## About the application

Application number: 2026/90666	
What is the application for?:	Rear landscaping and erection of retaining walls to the rear and side boundaries
Address of the site or building:	Sunnyside, 56, Heaton Road, Paddock, Huddersfield, HD1 4HZ
Postcode:	HD1 4HZ

DRAWING NUMBER: 26/4138/A3

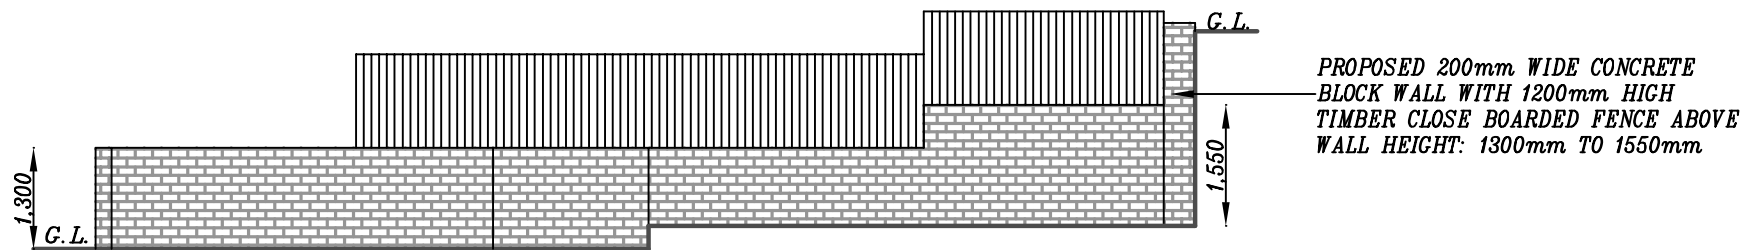
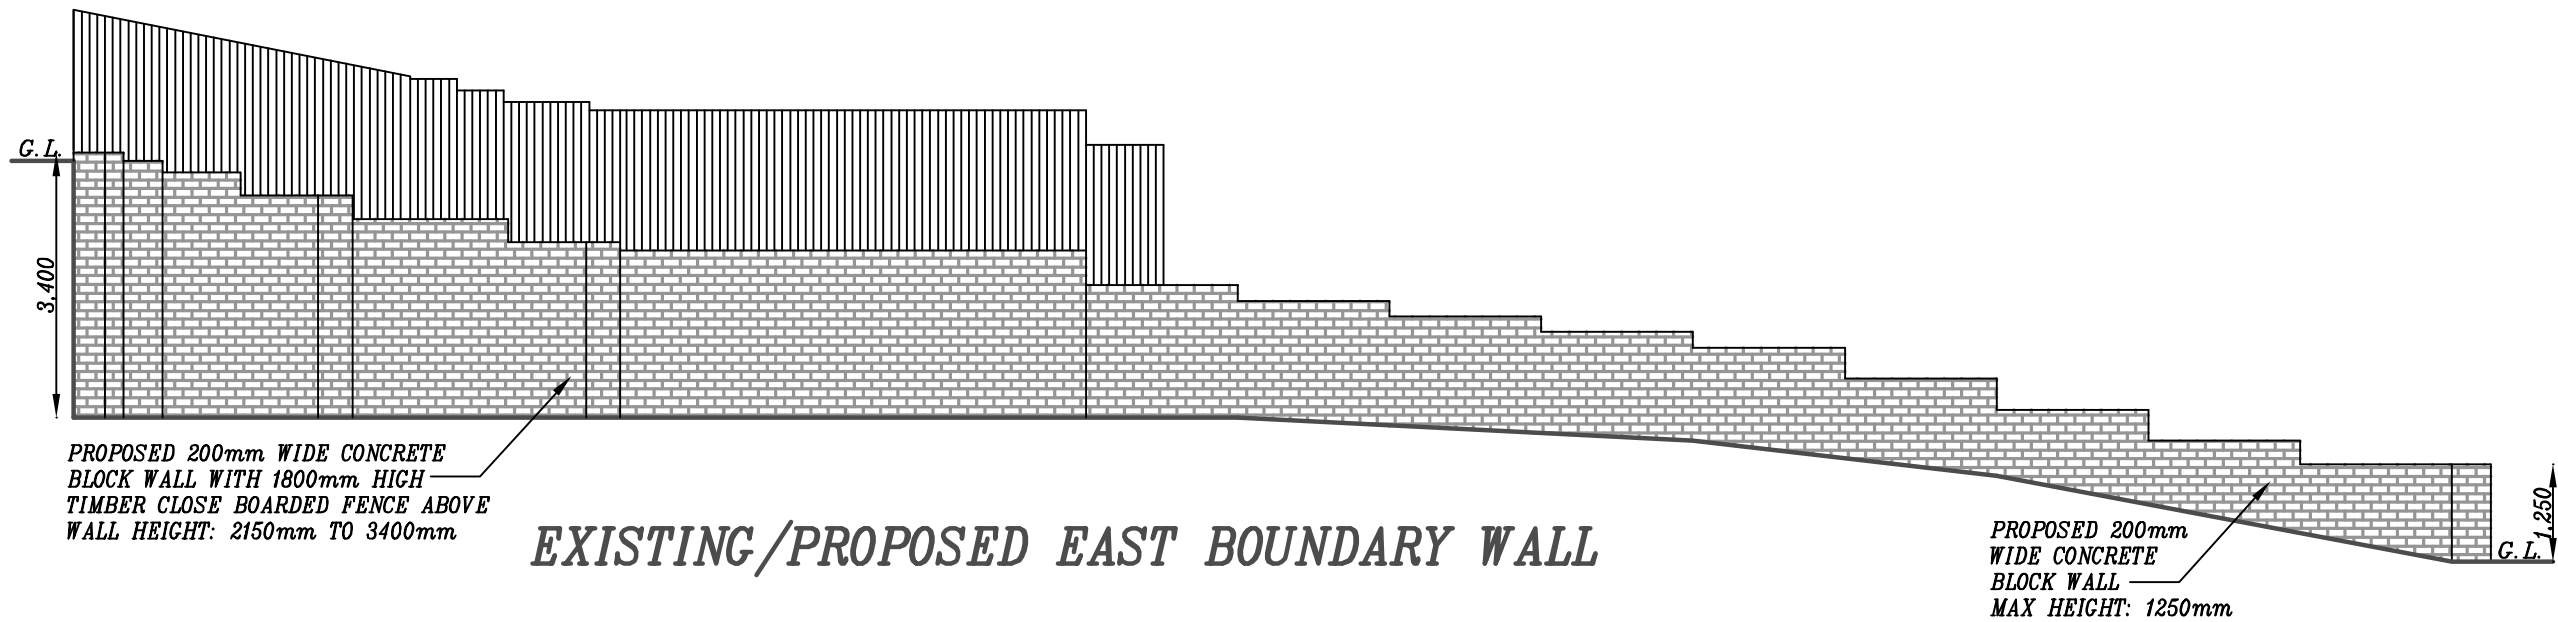
Type of comment: An objection	
Do you wish your comments to be published on the website anonymously?	<input type="checkbox"/> Yes
<p>the owner has carried out significant unapproved works, including major ground level changes, high retaining walls, and a steep impermeable driveway without a dropped kerb. The planning permission for the conservatory does not provide for the work completed. These works pose risks to pedestrians, increase flood risk, harm local visual amenity, decrease privacy and breach planning regulations. There are also safety hazards at the rear of the property and damage to a mature tree. Behind the house, there is a large gap between the rear retaining wall and the ground, big enough for a child to fall into. Wildlife such as hedgehogs or squirrels could also become trapped. The garden levels (front and rear) are now significantly altered. The retaining walls are visually intrusive, and not in keeping with the character of the street.</p>
